**Non-Material Amendments to Reserved Matters Approval ref: 18/00513/REM in relation to Village Centre (North)
Heyford Park, Camp Road, Upper Heyford, Oxfordshire, OX25 5HD**

This application seeks approval of a further non-material amendment to Building 100, to remove glazing panels from the western elevation of the building and to replace with brickwork to match the existing on this building.

3 PROPOSED WEST ELEVATION

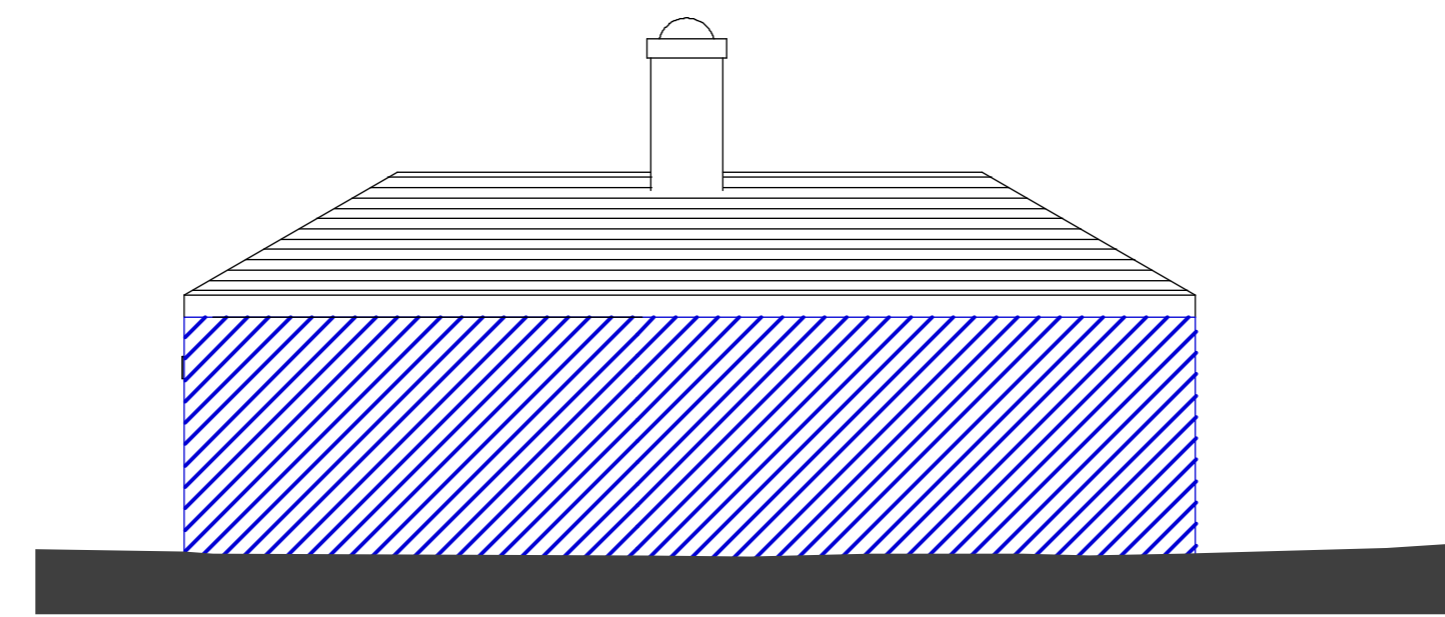
This application is made due to Building Regulations requirements for the approved glazing on the western elevation of Building 100. The Regulations require fire rated glazing here as the western elevation forms the notional boundary between Building 100 and Block A of the Village Centre North development. It is considered more appropriate for this elevation to be constructed in brickwork for the following reasons:

- Fire rated glazing would only provide for only one hour's protection in the event of a fire, therefore changing to brickwork helps to design out risk of fire spread to the residential apartments in Block A.
- The glazing required is considered prohibitively expensive for a secondary elevation of the building;

- There are significant lead in times associated with procurement of fire rated glazing, which would delay installation and completion of the development and, accordingly, the opening of Village Centre North.
